Application for Removal or Variation of a Condition following Grant of Planning Permission or Listed Building Consent

Full Planning for Erection of 1no. dwelling and cart lodge.

DC/22/01930

2. Approved Plans & Documents

Client:	P. Scales		Scale:	1:100 @ A1
Project:	Land to West of Blacksmith House Lower Layham, IP7 5LZ		Status:	Planning
Drawing:	Proposed Plans		Rev:	D
			Dwg No:	2021-445-010

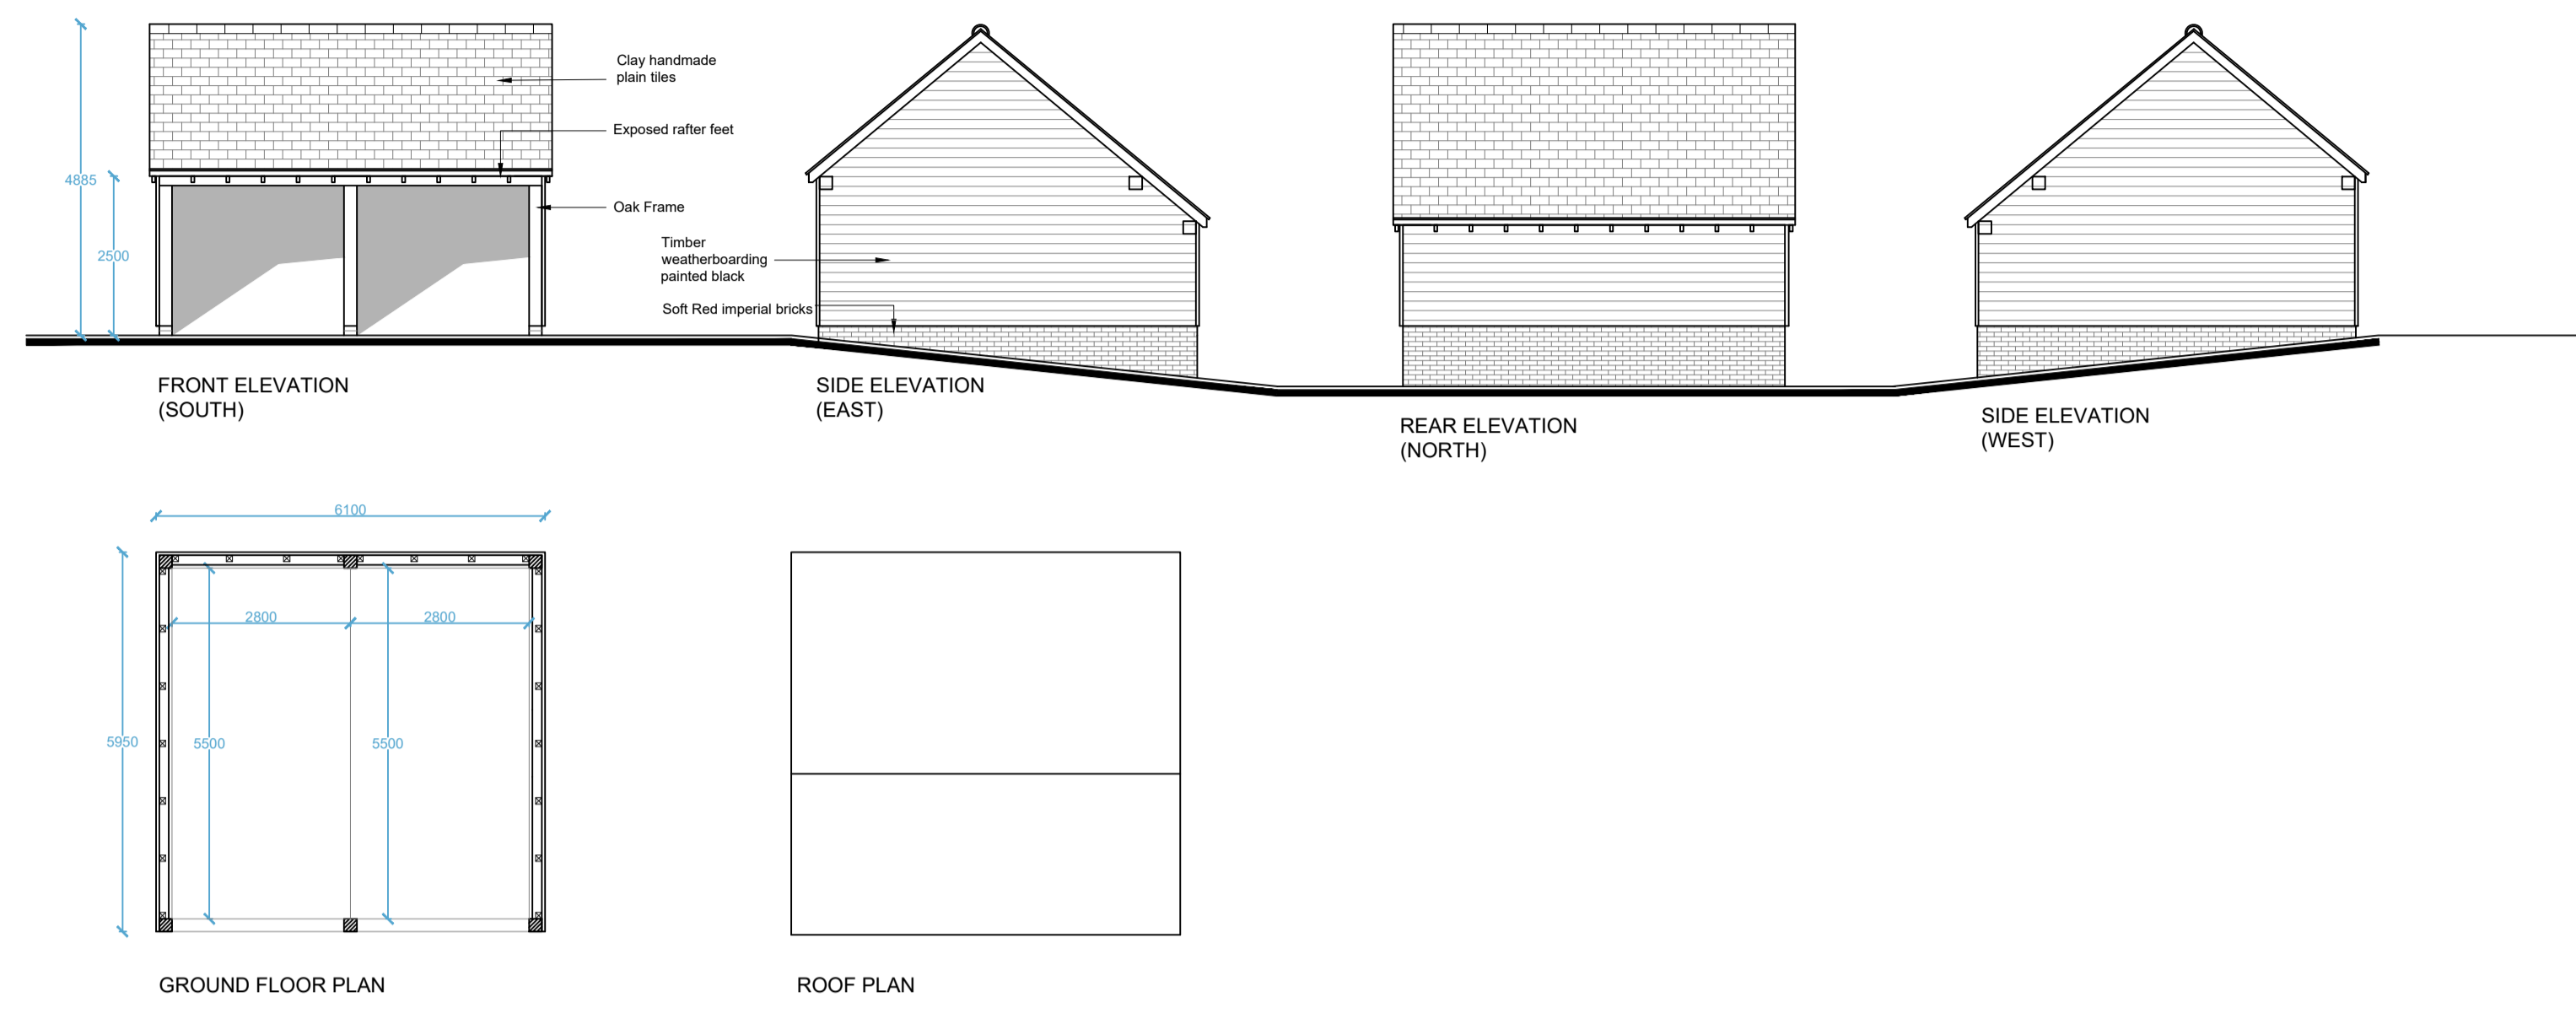
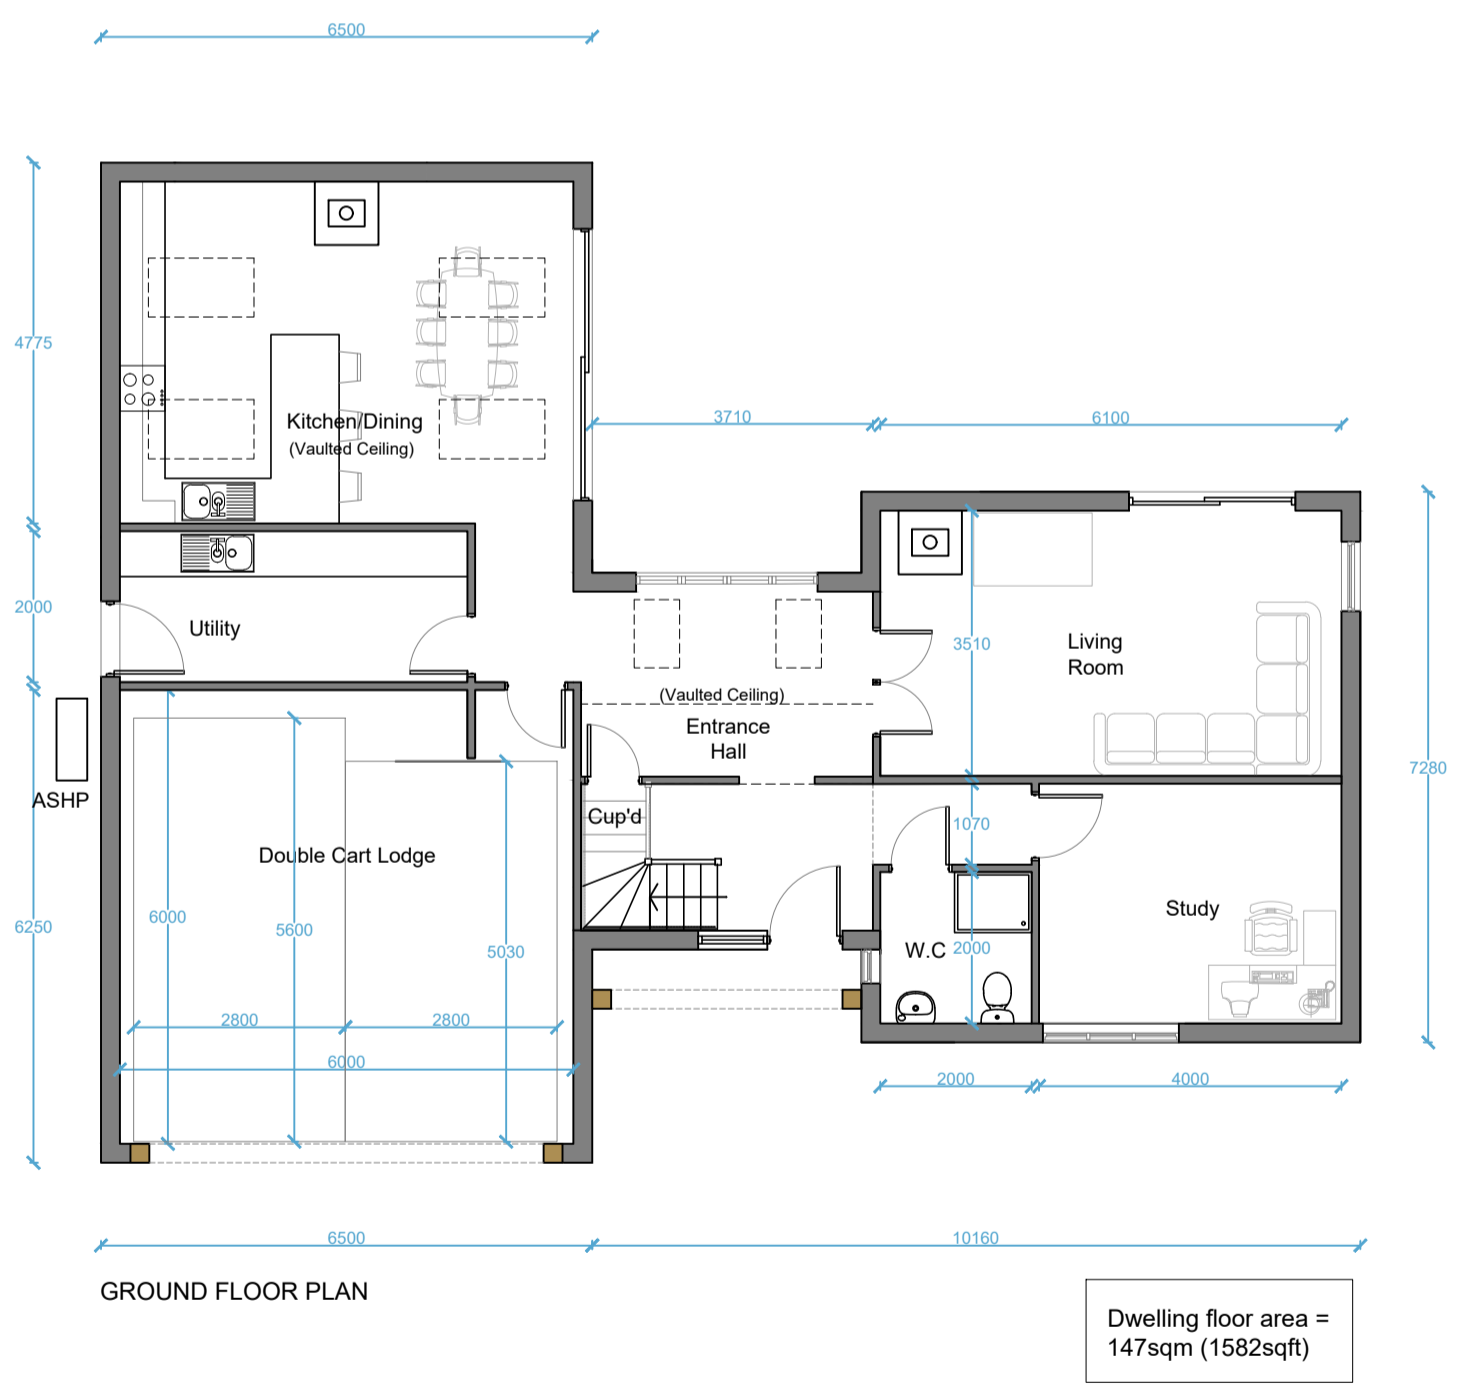
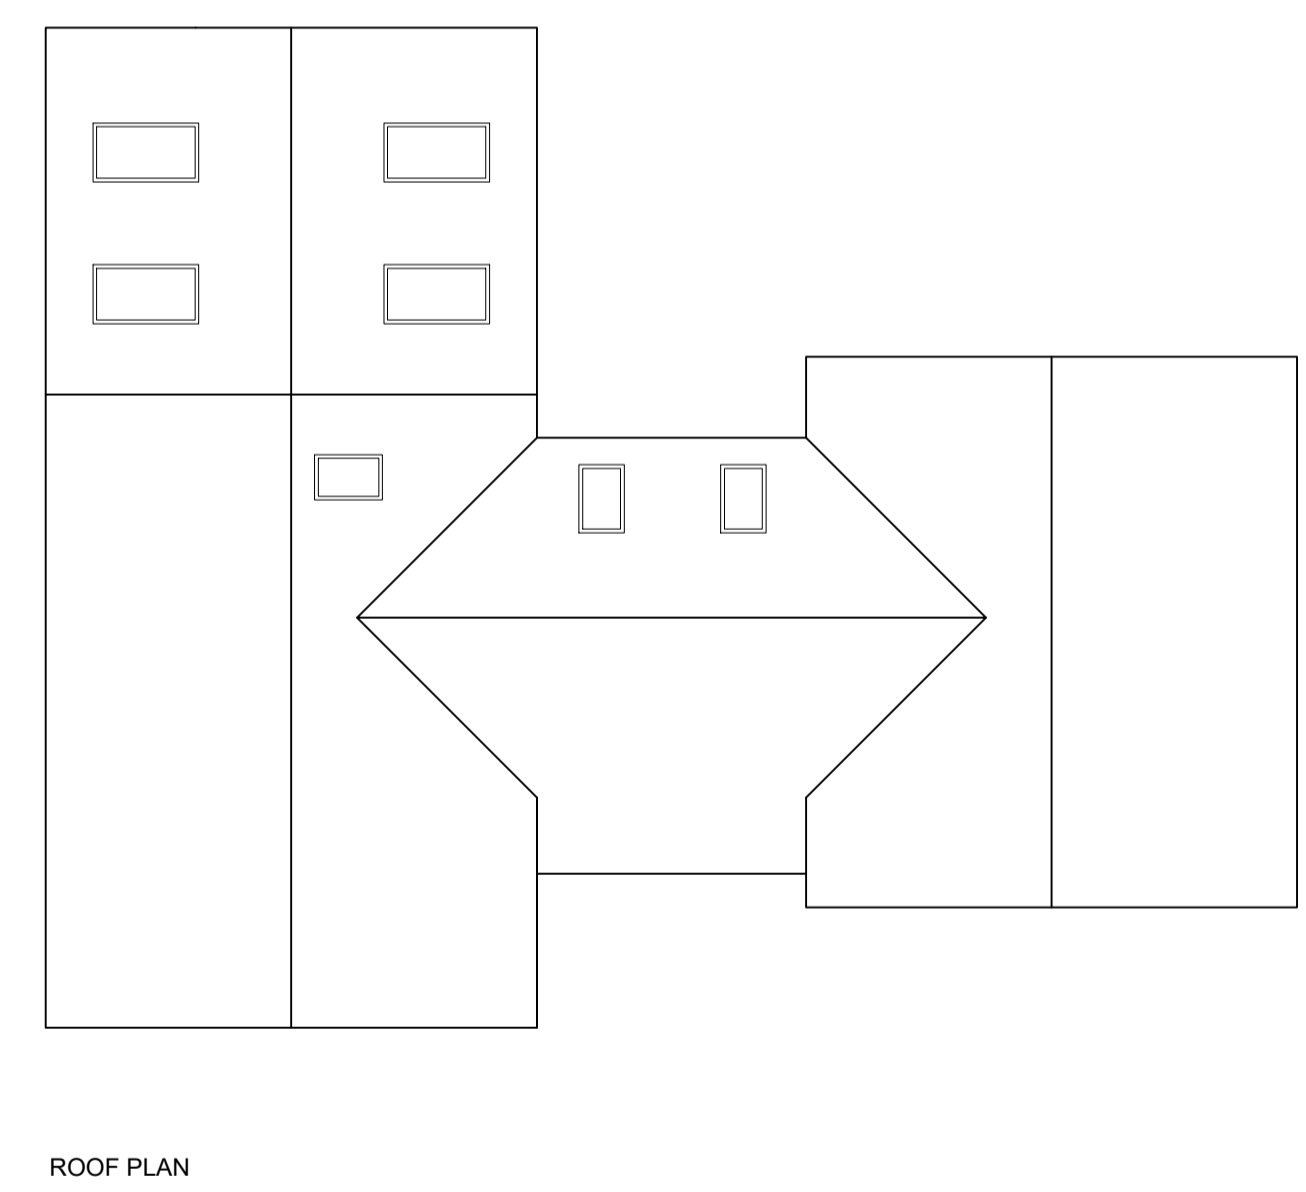
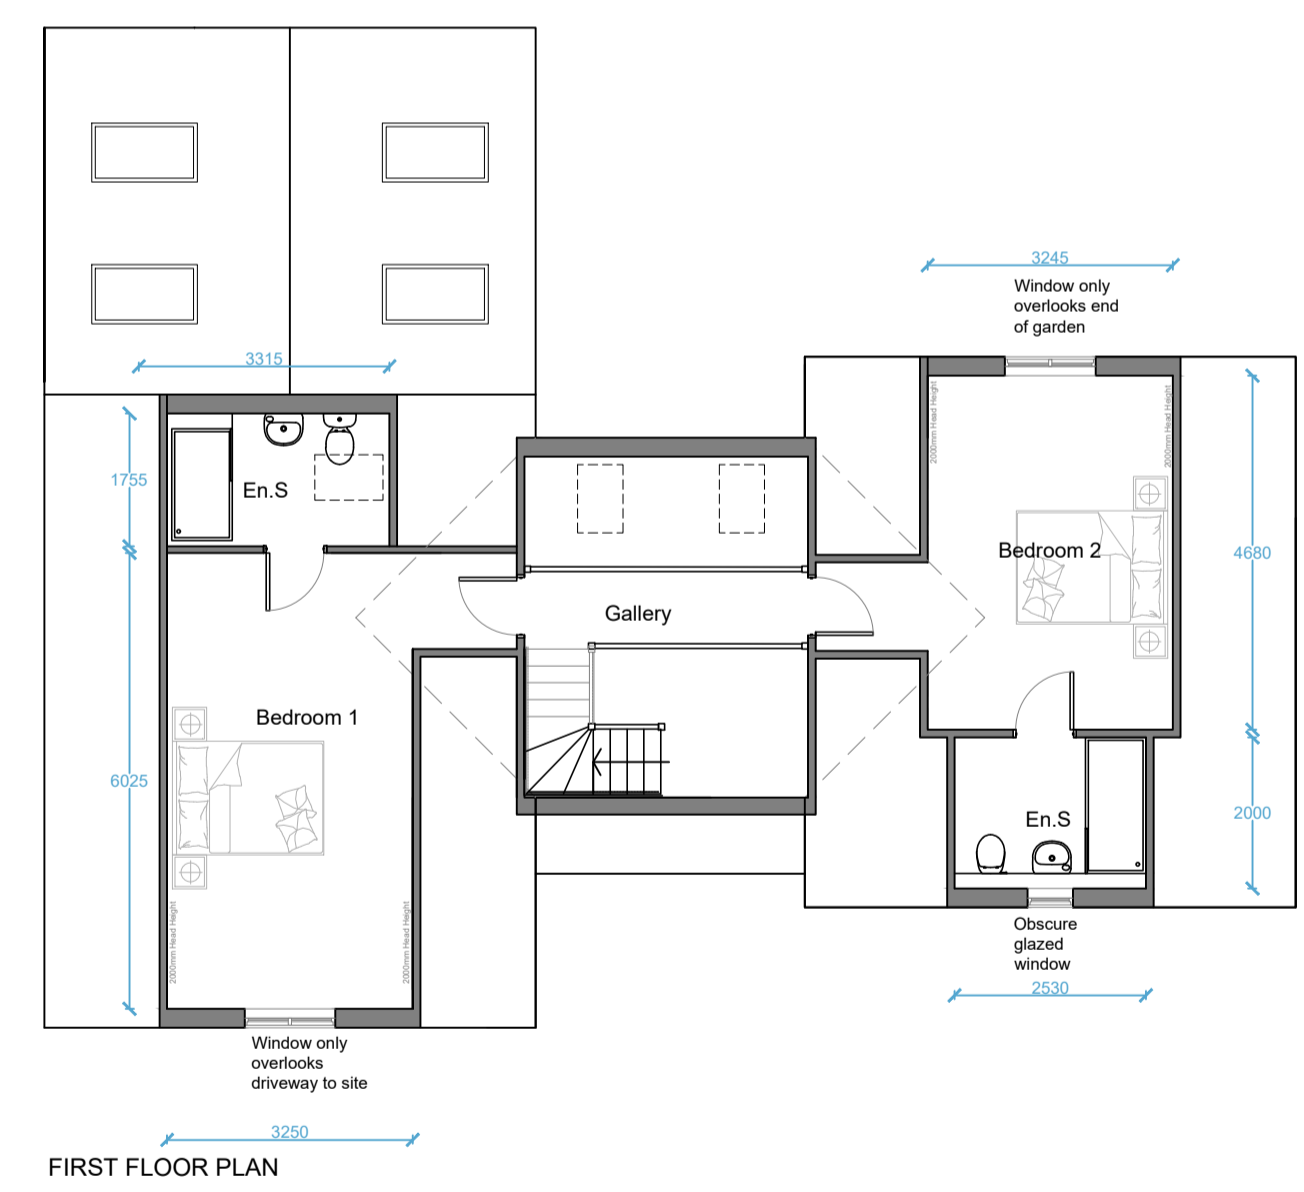
4. We seek approval that we extend the width of the single storey such that the walls and roof ridge lines on the south are aligned . This will involve removing the utility window and inserting a half-glazed utility door. Also to add roof windows on the south elevation of the single storey

5. We seek approval to remove the centre post shown in the centre of the carport to enable better access.
